Case Officer: George Smith

Recommendation: Refuse

Proposal: RETROSPECTIVE - to retain storage container to rear of petrol filling station kiosk

Expiry Date: 19 March 2020

Proposed Plans, Elevations and Location Plan

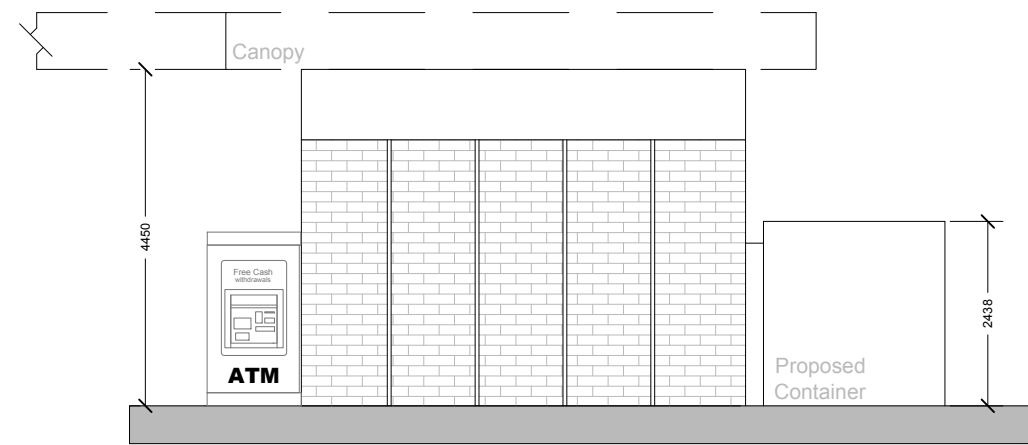
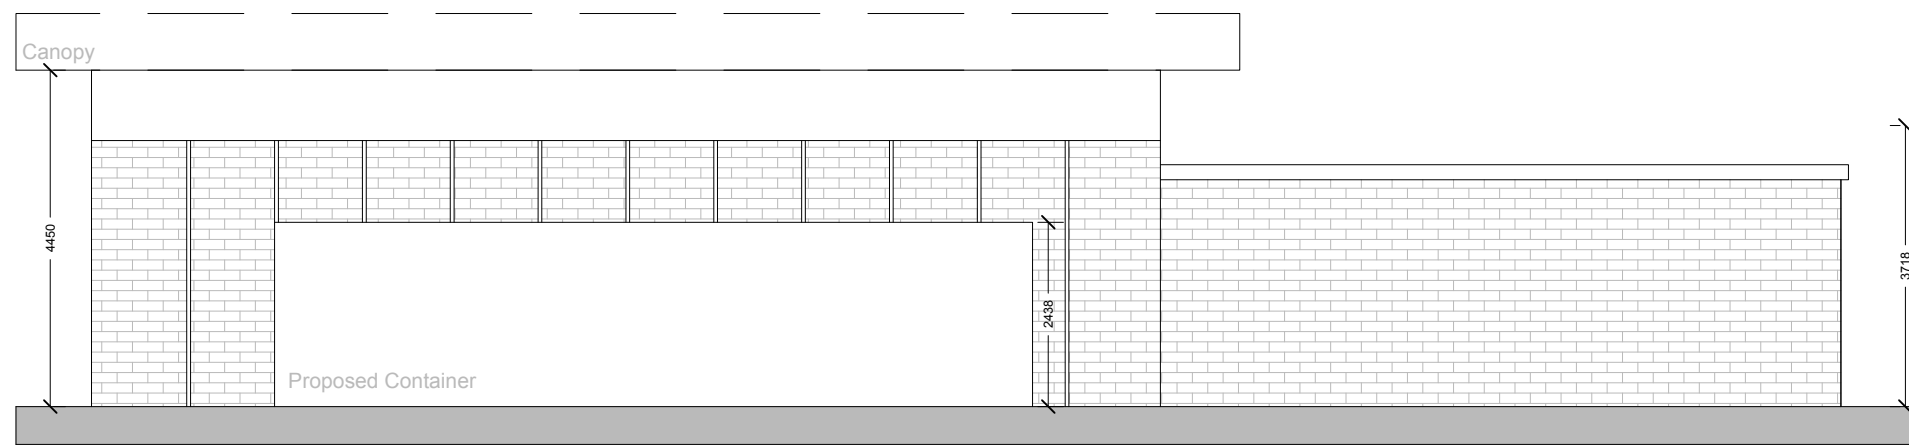
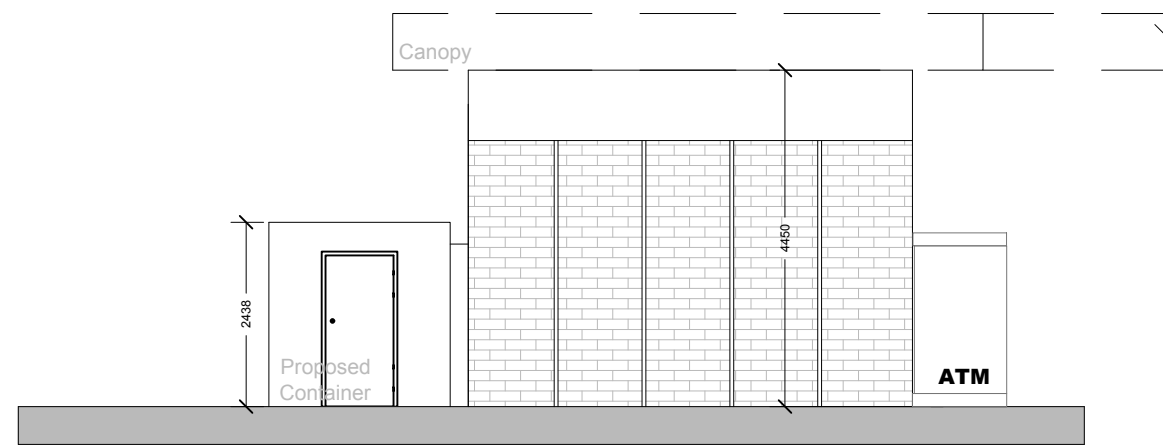
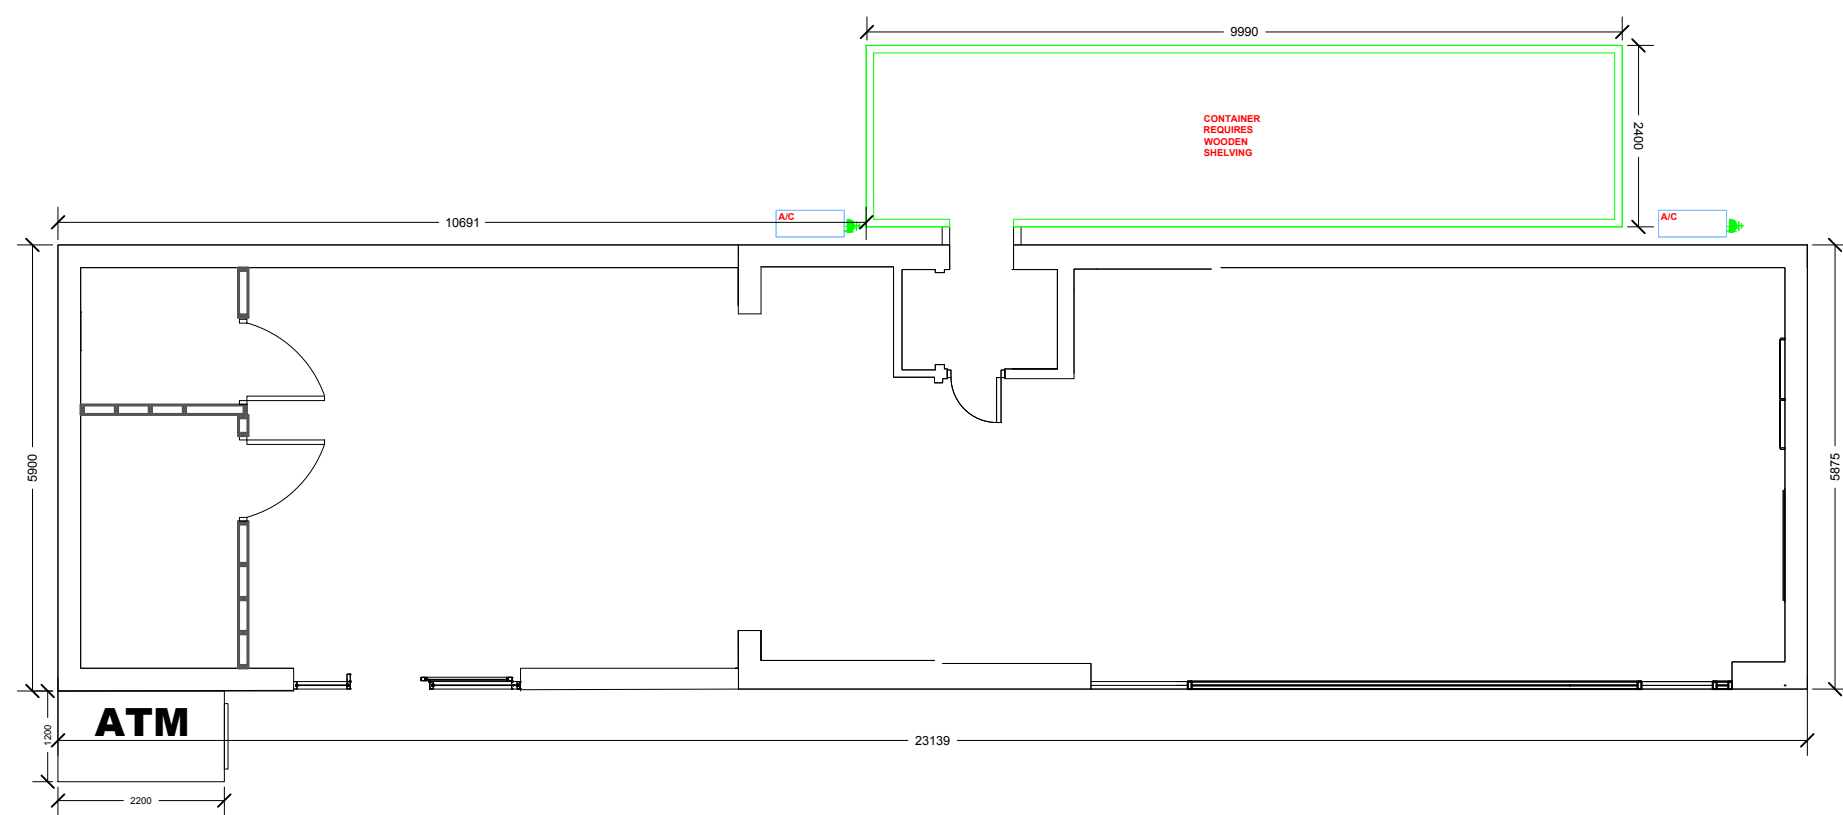
- 2.1. The applicant seeks retrospective consent for a shipping container, located between the south-eastern boundary of the site and the service station shop building. The container is 9.99m x 2.4m (d x w), made of grey painted metal. The container is used for the storage of dry goods.

- 8.7. Despite its siting to the rear of the kiosk entrance, because of the orientation of the buildings the shipping container is clearly visible from the public domain on Oxford Road. The petrol station serves as a functional facility in this edge of village location, and whilst it is recognised that its use, the adjacent car sales uses and the Oxford Road bring with them elements of urbanisation, the container itself is considered to be an inappropriate permanent fixture in this village location, directly adjacent to residential uses, where alternative, more site sensitive and less visually harmful options appear available. Officers therefore consider that the proposal result in significant harm to the character and appearance of the area, failing to comply with Policy ESD15 of the CLP 2031, saved Policies C28 and C31 of the CLP 1996 and relevant paragraphs of the NPPF.

1. By virtue of its design and siting, and without sufficient justification for the discounting of alternative, less harmful options, the shipping container results in significant harm to the character and appearance of the area. The development is therefore contrary to Policy ESD15 of the Cherwell Local Plan 2031, saved Policies C28 and C31 of the Cherwell Local Plan 1996 and relevant paragraphs of the National Planning Policy Framework.
